Re: 2026/62/90356/E

Erection of dwelling and associated works; Bell Cabin, Long Lane, Earlseaton, Dewsbury, WF12 8LG

The Coal Authority response: **Material Consideration**

Title
**EARTHWORKS
MINE SHAFT CAPPING
ARRANGEMENT
SECTIONS**

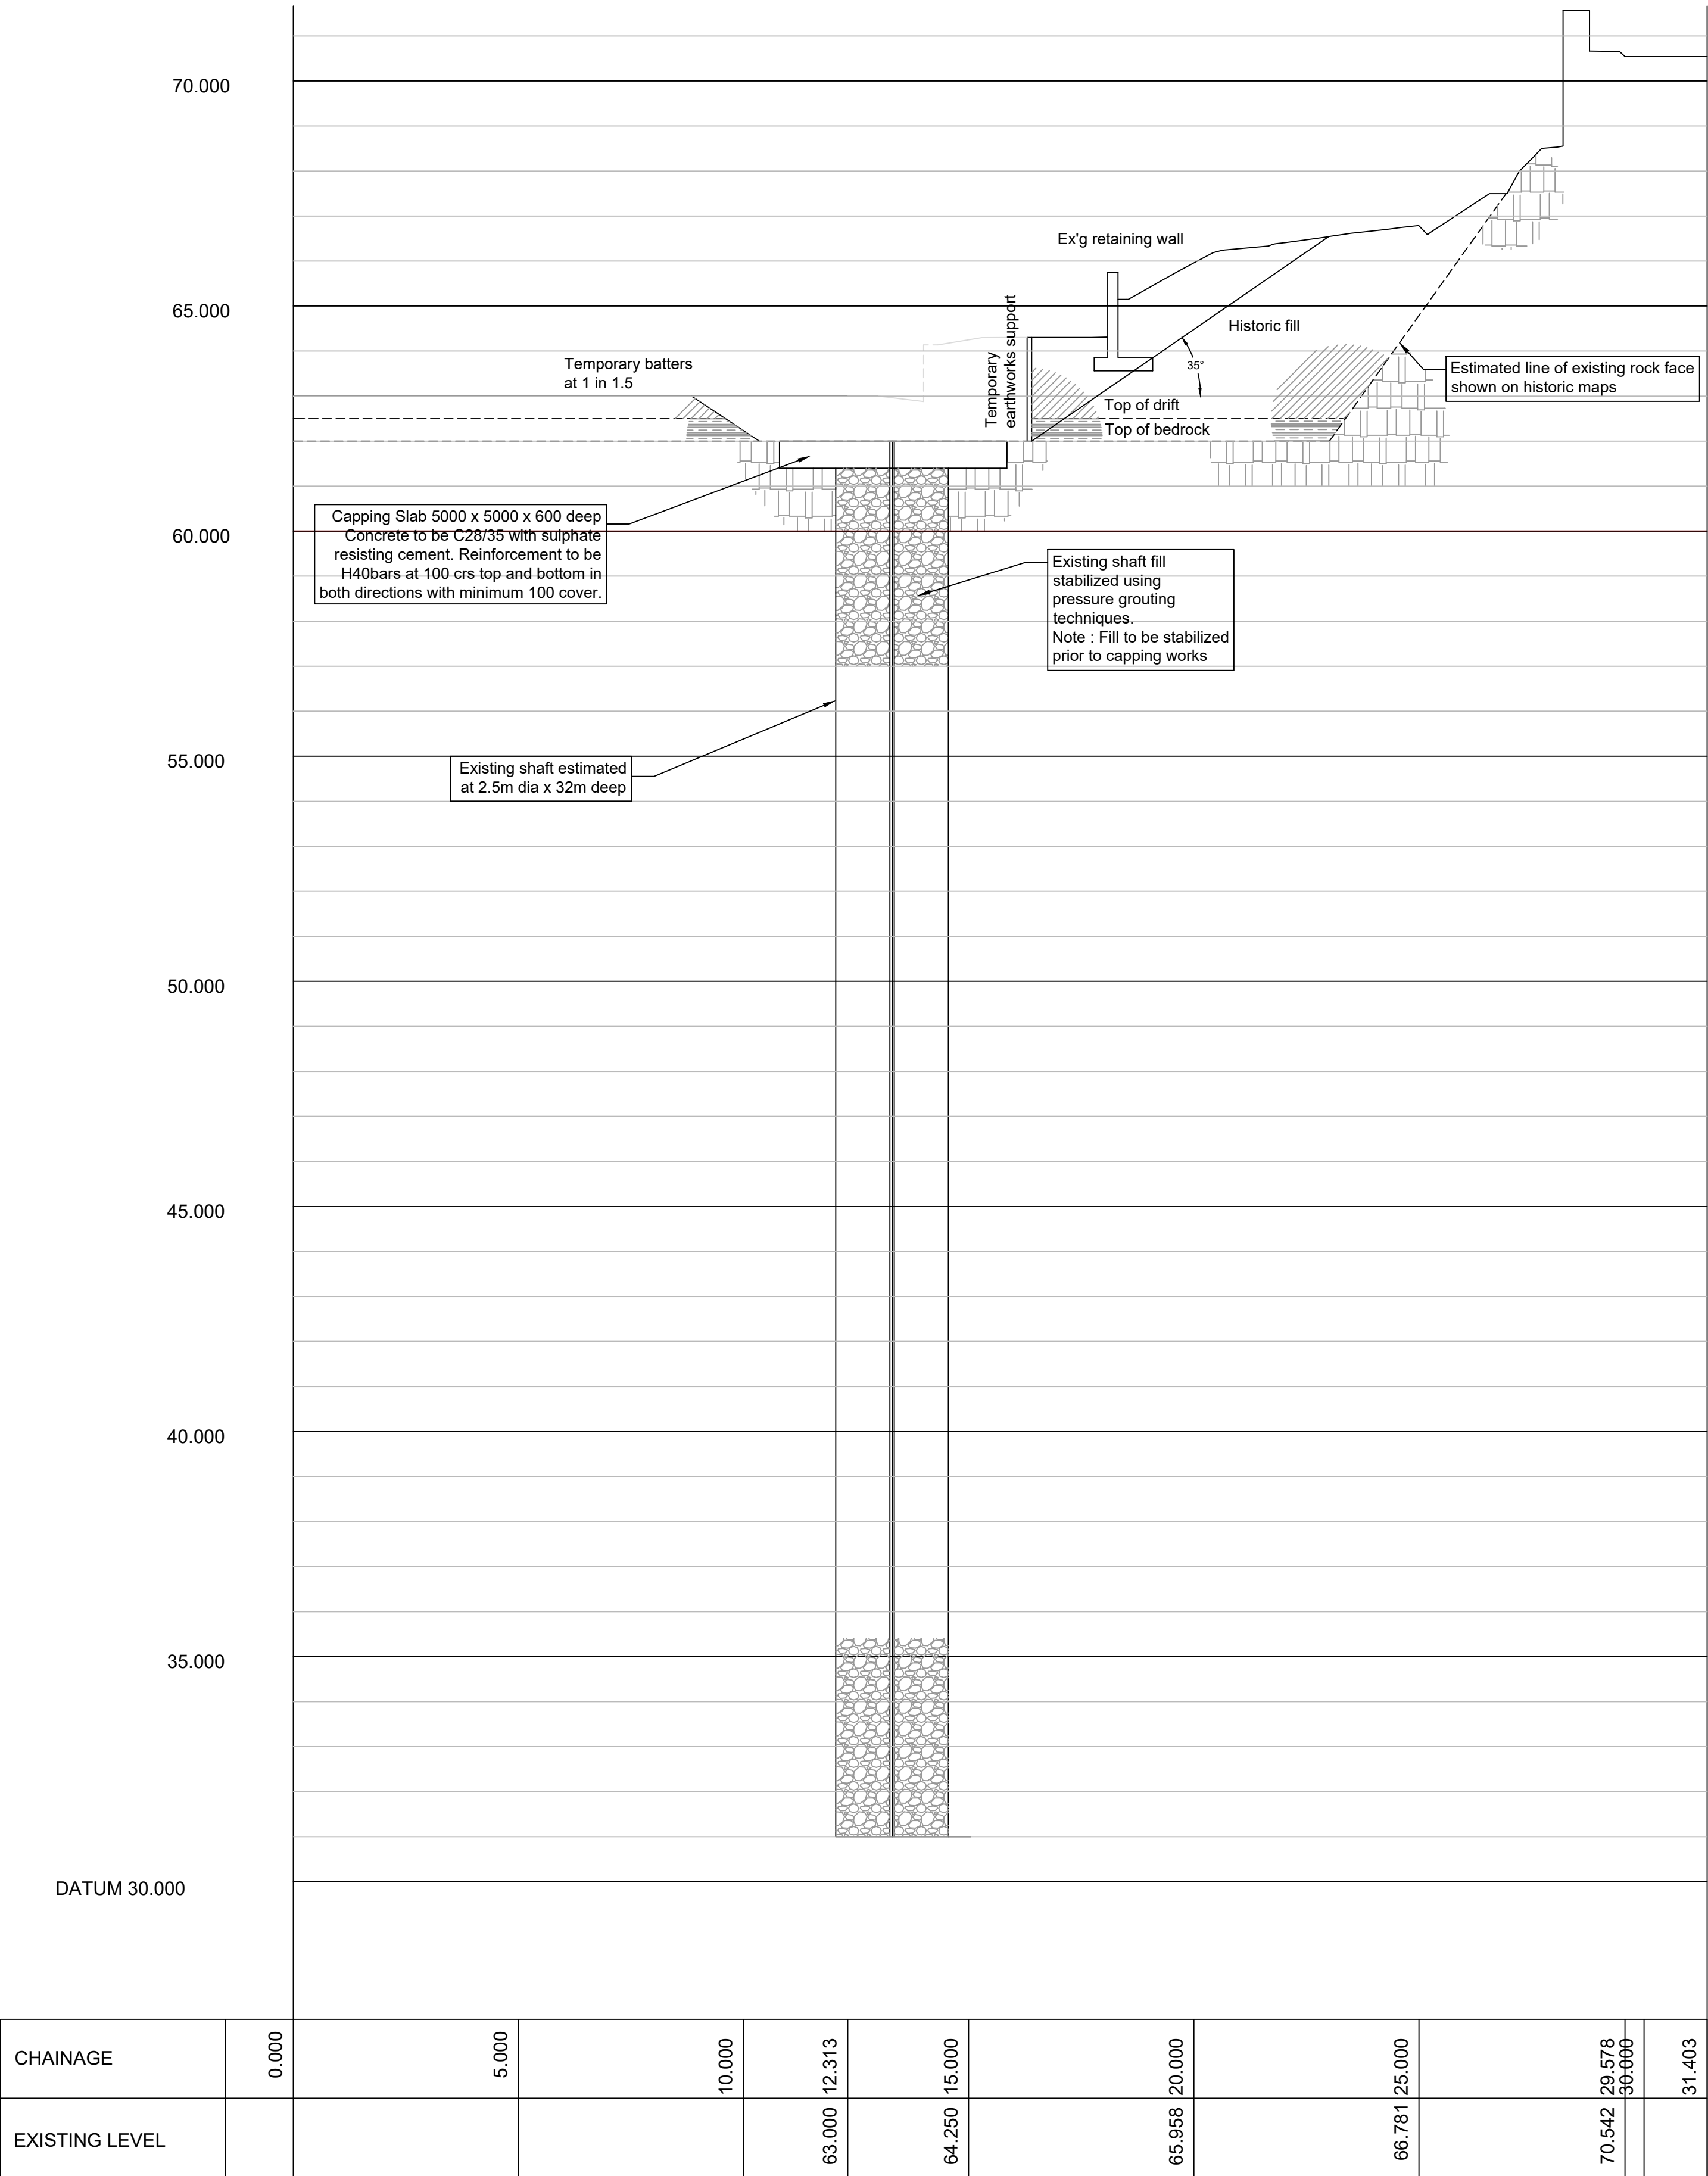
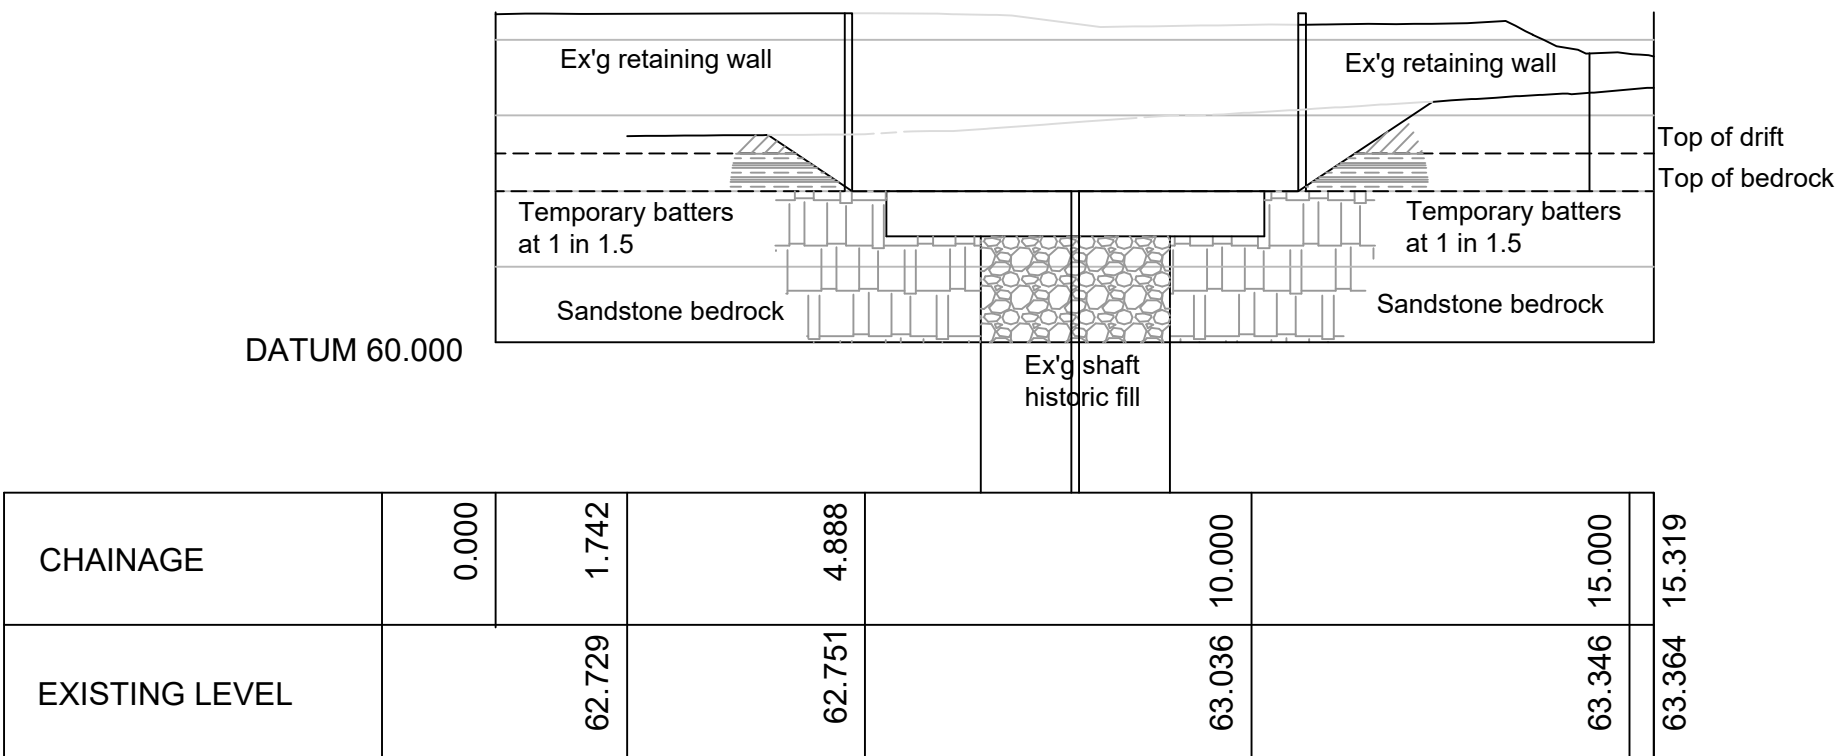
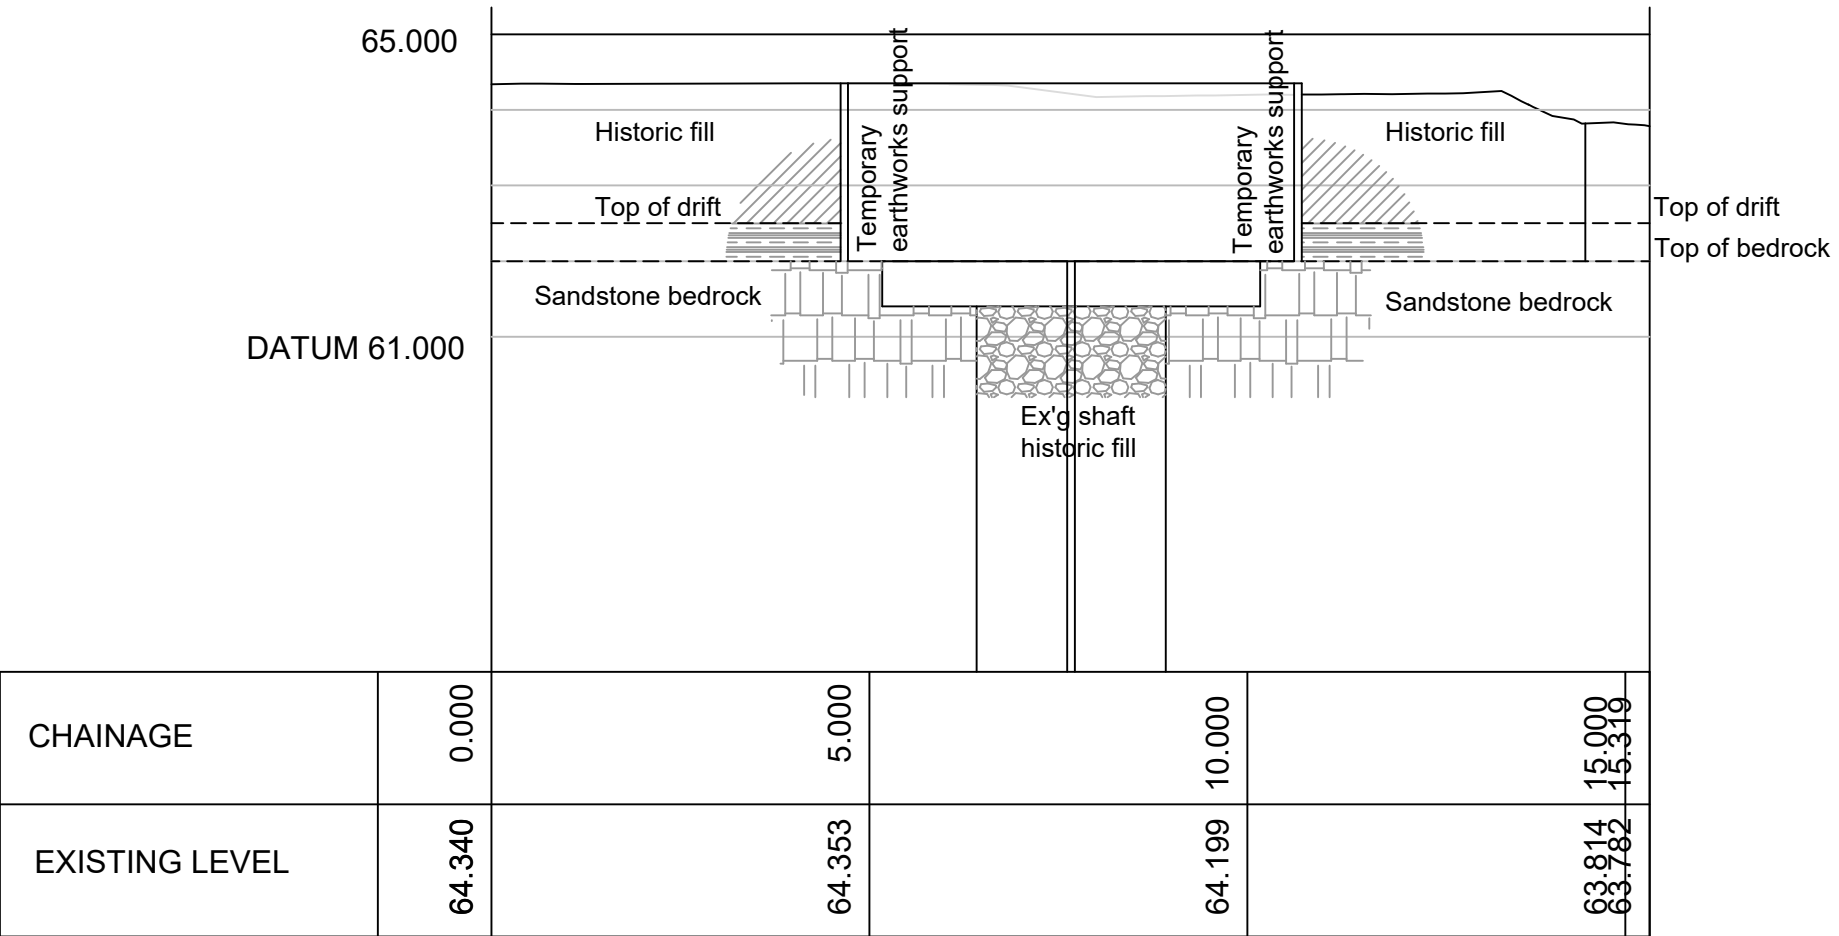
The Coal Authority records indicate that within or within 20m of the site boundary there are two mine entries (1 x on-site mineshaft -CA ref:425420-004 and 1 x off-site mineshaft: CA ref 425420-006) The Coal Authority hold information for the on-site mineshaft and that this was *"encountered by Geoinvestigate Ltd. Shaft found to be filled with colliery spoil"*. We hold no treatment details for the off-site mine entry. Any untreated or inadequately treated mine entry poses a significant risk to public safety and surface stability for the redevelopment of this site.

The Coal Authority is of the opinion that building over the top of, or in close proximity to, mine entries should be avoided wherever possible, even after they have been capped, in line with our adopted policy: [Building on or within the influencing distance of mine entries - GOV.UK](#) In accordance with Drawing No. (100) 03) Proposed Site Plan, illustrates the *"Zone of Influence of capped mineshaft as per application: 2022/62/90804/E. Mine Shaft Drilling Investigation Report"*.

We note that the proposed site layout plan for this current application, illustrated the red area shows the zone of influence of a capped mineshaft, and therefore we are assuming that the treatment works have now been undertaken. However the Planning team at the Coal Authority have not had sight of or reviewed any information on any treatment works carried out at the site. It is assumed that the LPA have no knowledge of said information.

In light of the above, we would have no objection to the proposed development in accordance with the proposed layout (Drawing No. (100) 03) Proposed Site Plan) as the proposed dwelling is illustrated as being outside the zone of influence of the mineshaft. However we would recommend that the LPA impose the same, or similarly worded condition (Condition 7) as per the approved development: 2022/62/90804/E.
